27th March 2008

Outline application for the erection of 1 no attached dwelling.
14 Tangmere Gardens Aldwick

SITE PLAN - 1/500

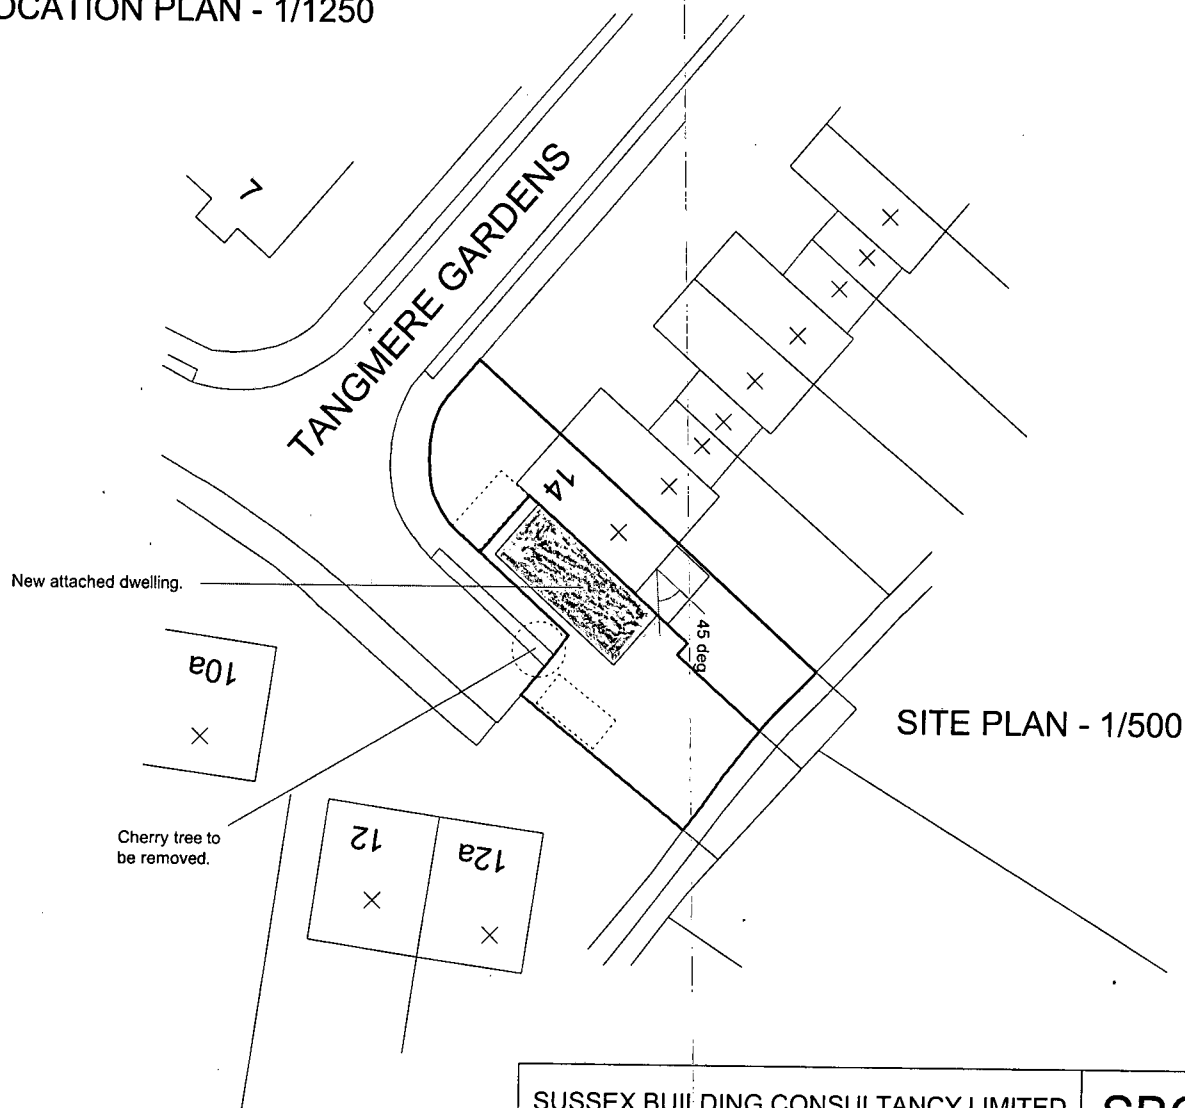
Members believed that POLICY GEN7 would be contravened if this application were to be allowed. It would not protect or enhance the quality of the existing environment, which is mainly detached and semi-detached properties. Also the style would be out of keeping with the area. Furthermore the new dwelling would prevent access to the existing property which is on the side where the new house would be built - there is no request within the plans for changed access to No. 14. The request is unneighbourly, represents over-development of the plot and would increase the existing parking problems in the vicinity. ☐
Ron Palmer, Parish Clerk
